Botley West Solar Farm Ref: EN010147 - Deadline 1: June 4th 2025
For the attention of the Planning Inspectorate. Our reference number: RR 0413

Botley West Solar Farm: Written Representations, absorbing information from earlier submissions, accompanying ICOMOS-UK's Registration as an Interested Party, including a Summary and overlays on the Applicant's 'Botley West Solar Farm Preliminary Masterplans'.

These comments and Masterplan overlays are from the Cultural Landscapes and Historic Gardens Committee of ICOMOS-UK.

Project: AG1803	Sheet: Field 2.118
Date: November 2024	
Scale: 1 : 3500 @A3

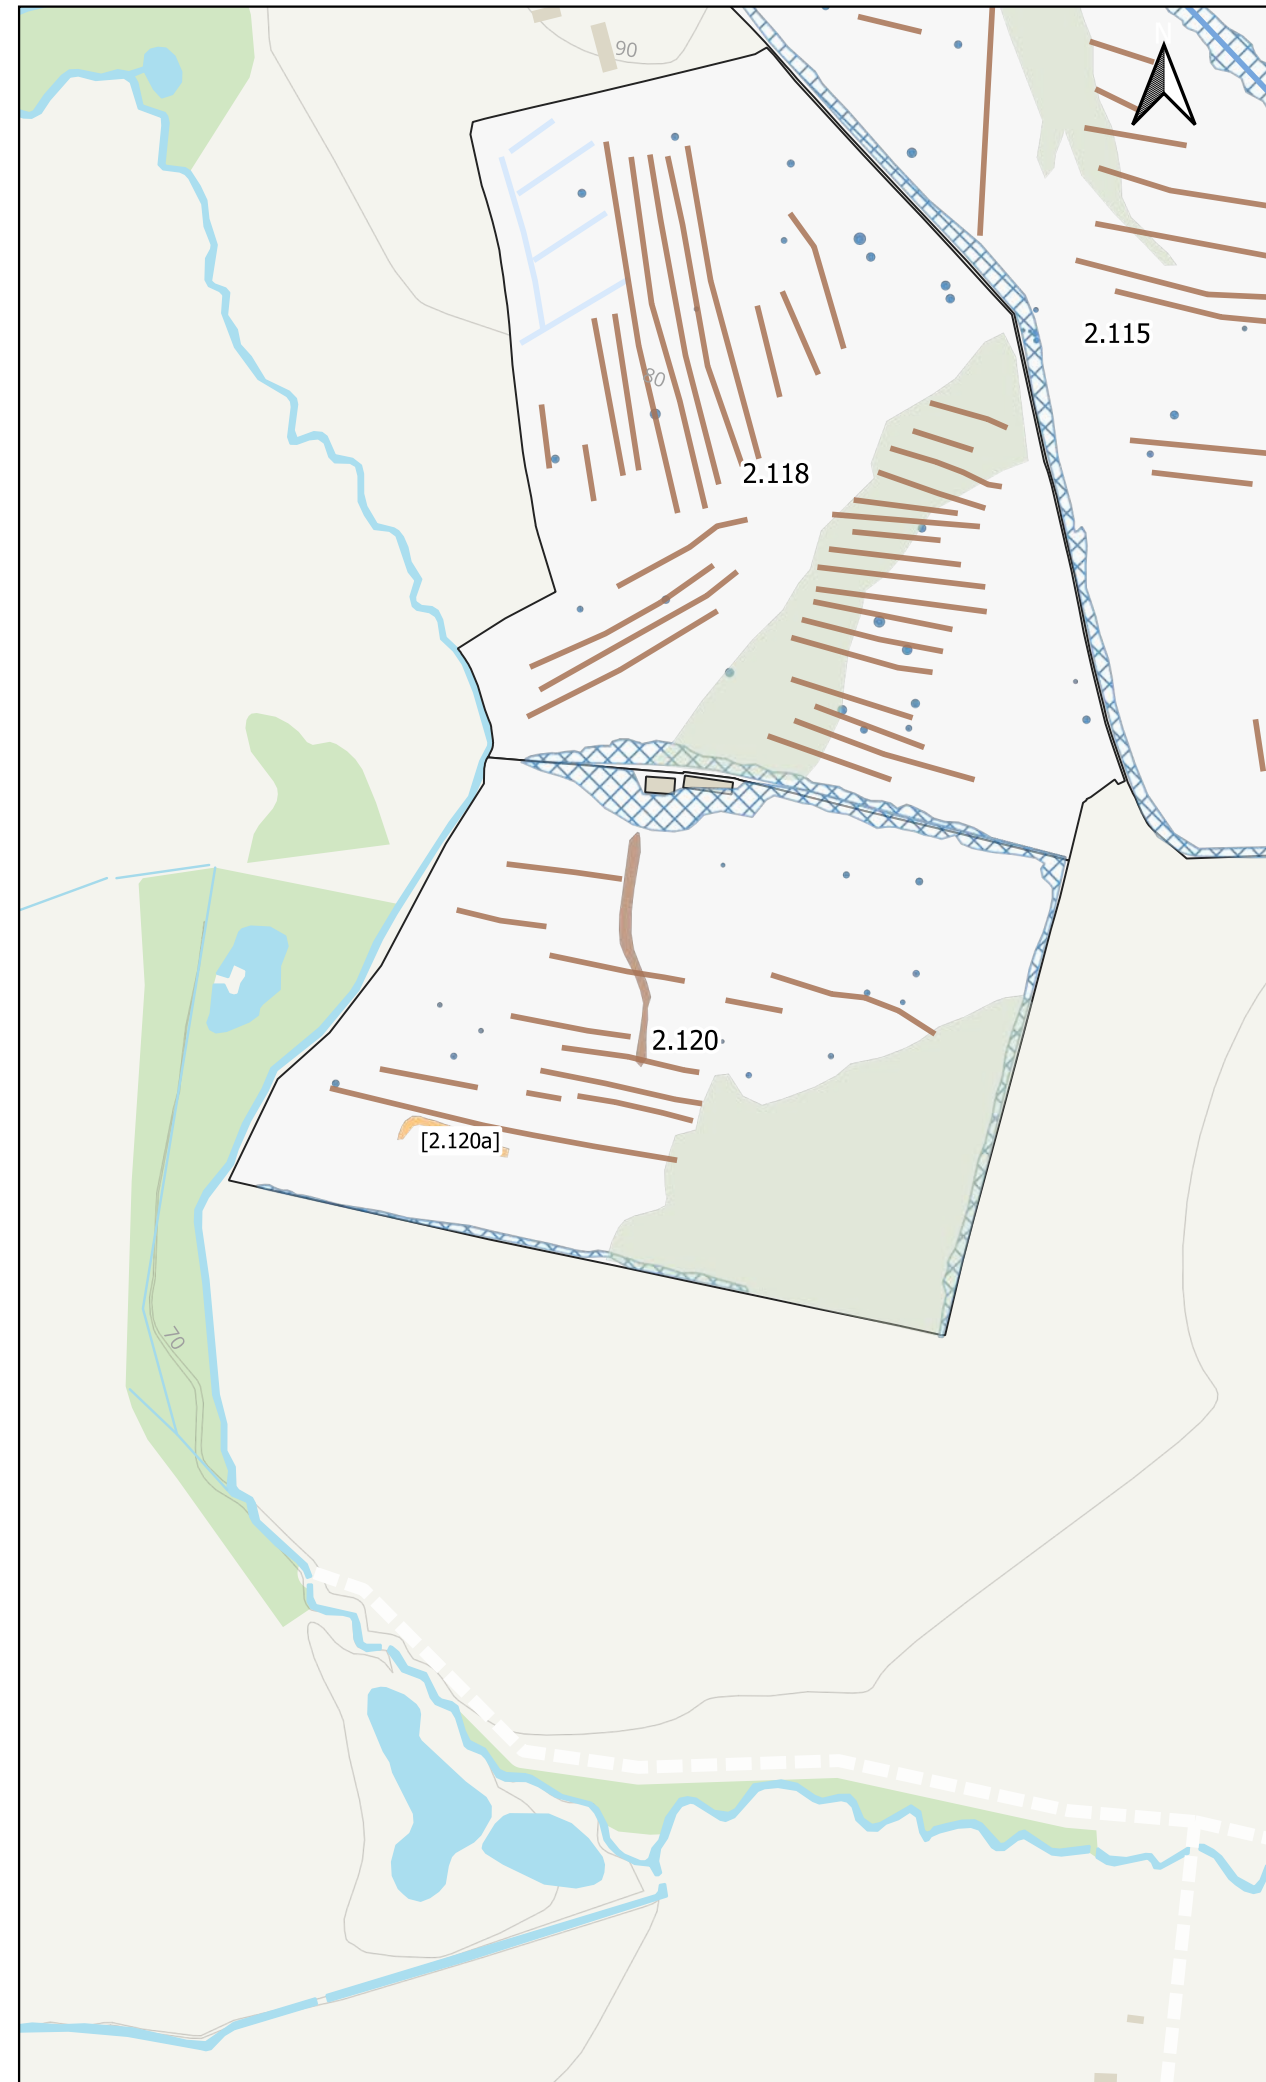
Church Hanborough's soaring limestone steeple can be seen across fields from every point of the compass (England's 1000 Best Churches by Simon Jenkins). To conserve most of these views and the setting of the village, in particular the rural scenery of the valley passing the western side of the village, **no solar arrays should be placed on the sloping sides of the ridge to the south of Chuch Hanborough village [2.115 NW arm; 2.118; 2.119; 2.120]** (as indicated on the west side of Masterplan-Middle Section 3).
